## RECYCLING & REFUSE TRANSFER STATION

# BARBARICK WASTE TRANSFER STATION

## SITE PLAN EXHIBIT - AL2310

SITE PLAN EXHIBIT - AL2310

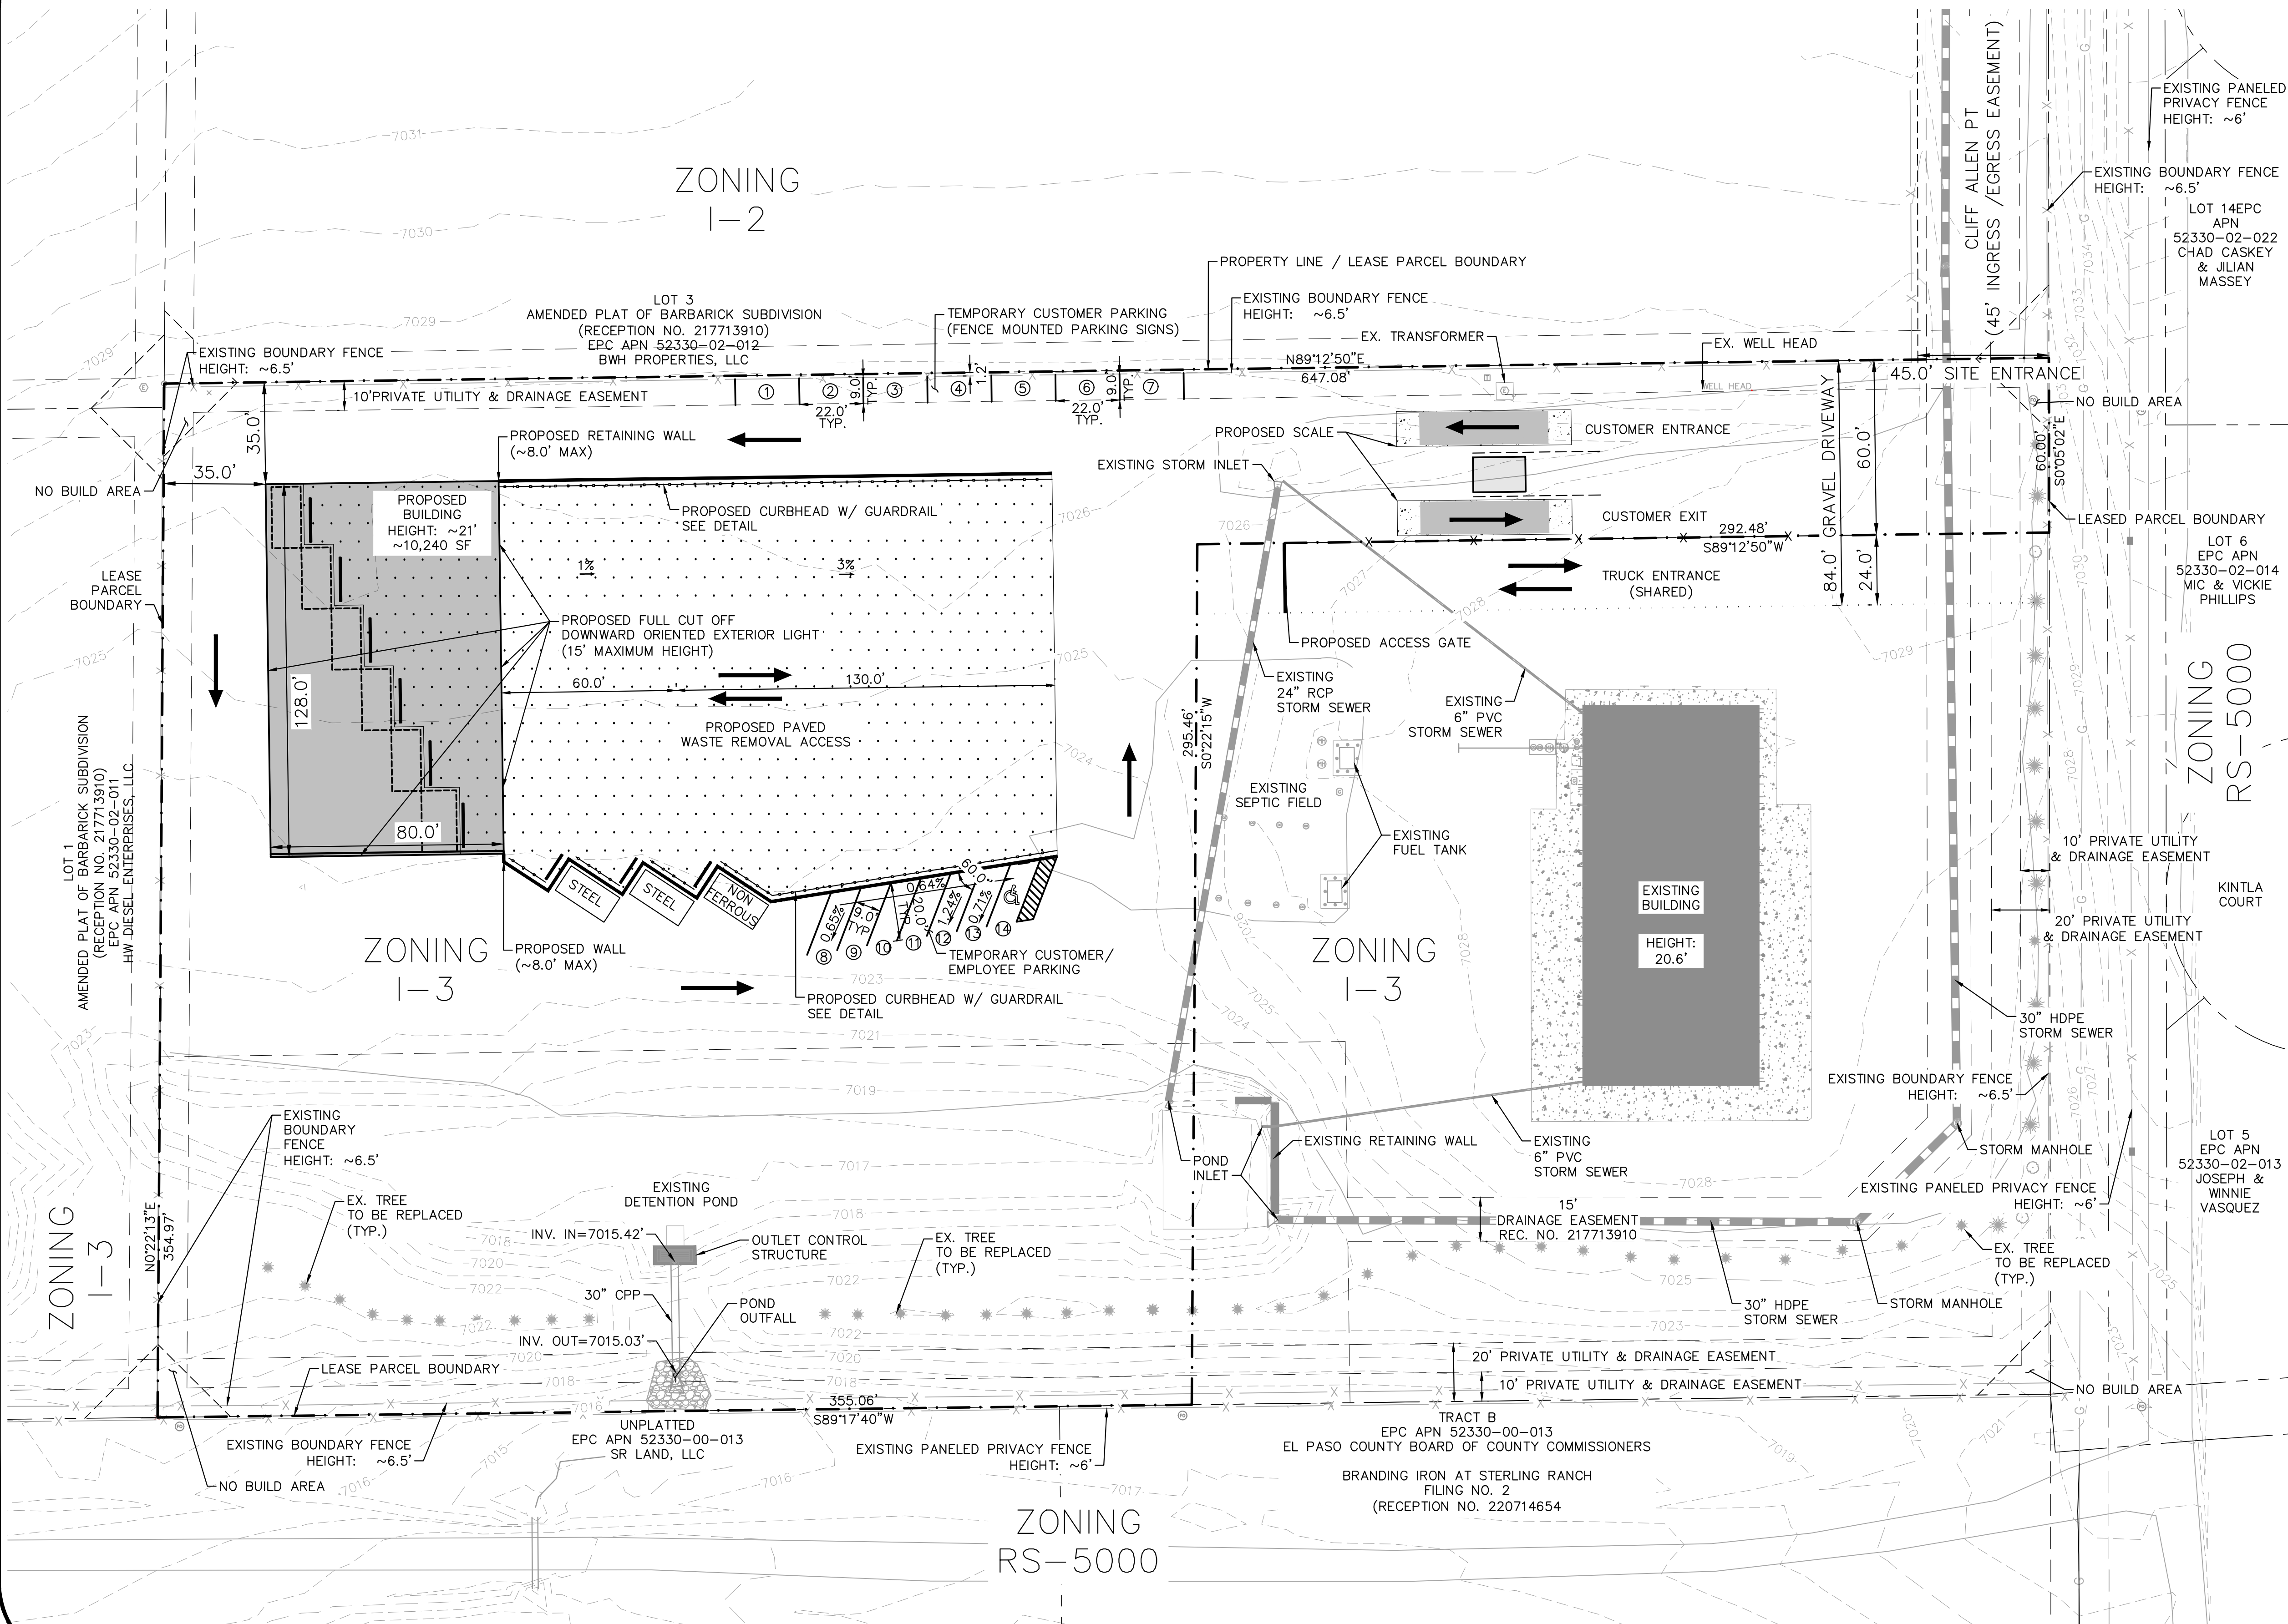
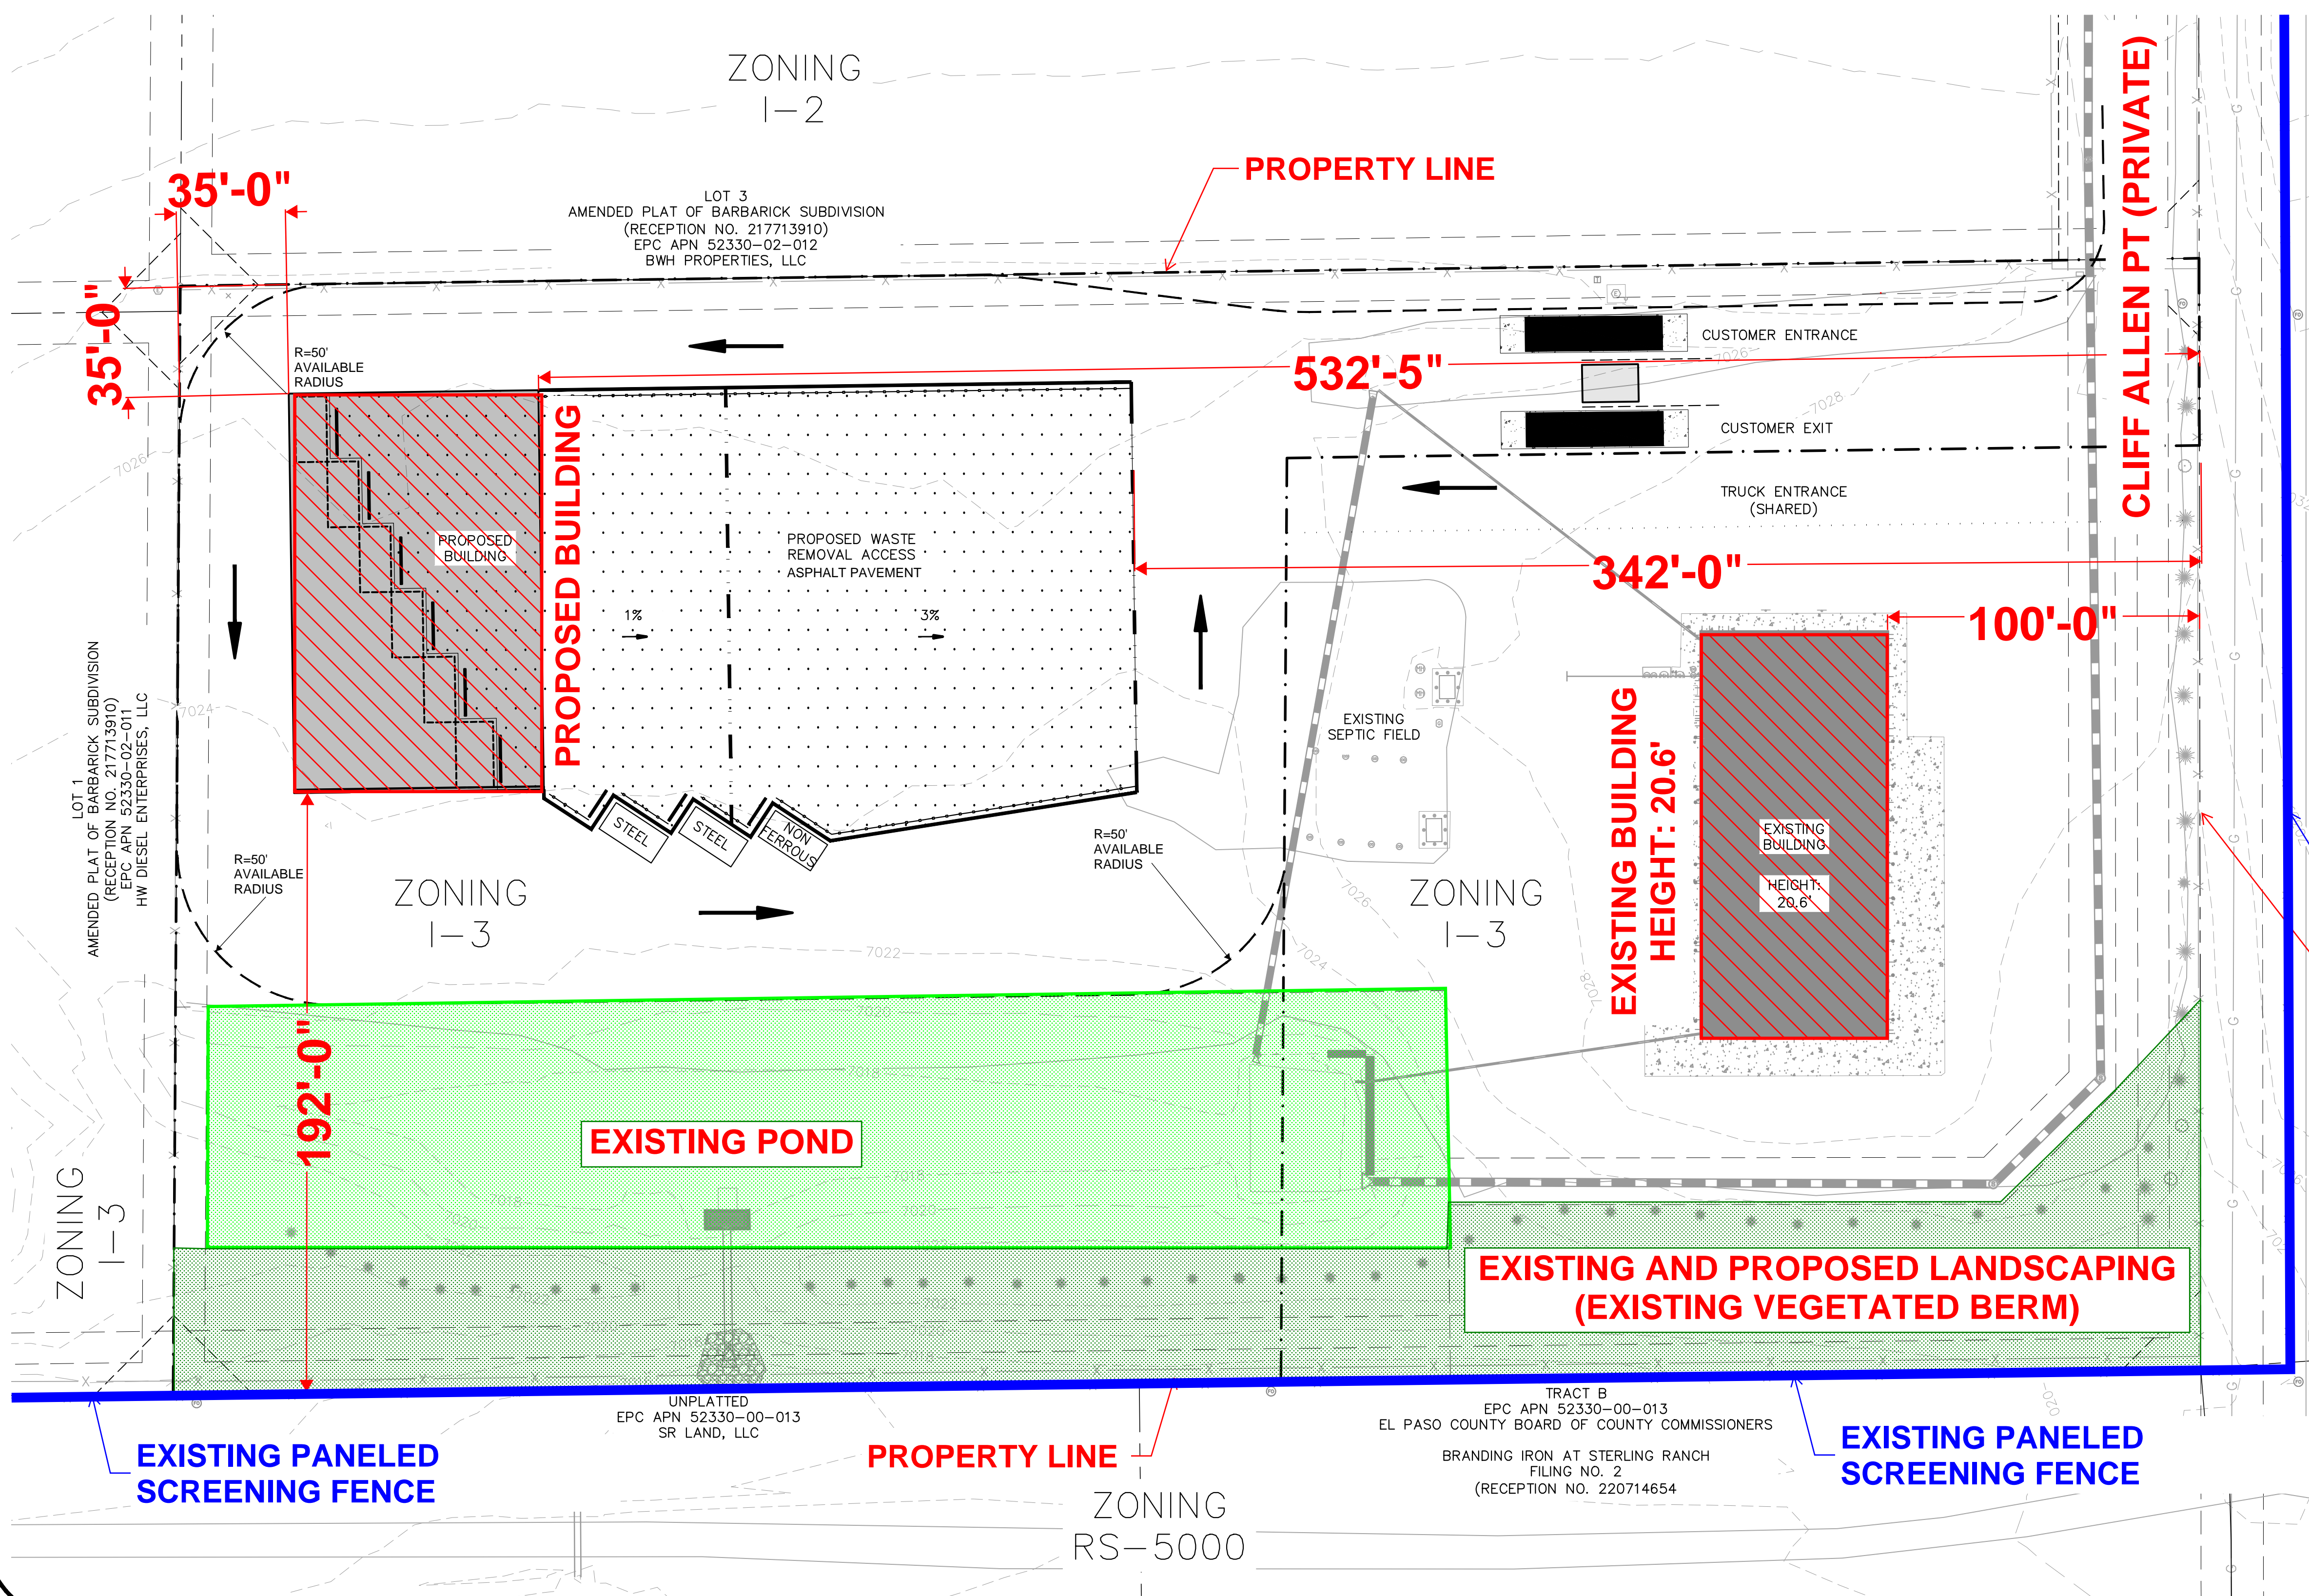
**UNRESOLVED V1 COMMENTS:**  
 v2:  
 -signage? provide dimensions  
 -required vs provided parking (6-2 minimum parking requirements table)  
 industrial use requires 1 space/750 sq ft of use  
 -ADA parking,ramps,signs  
 - location and height of outdoor illumination  
 - well placement
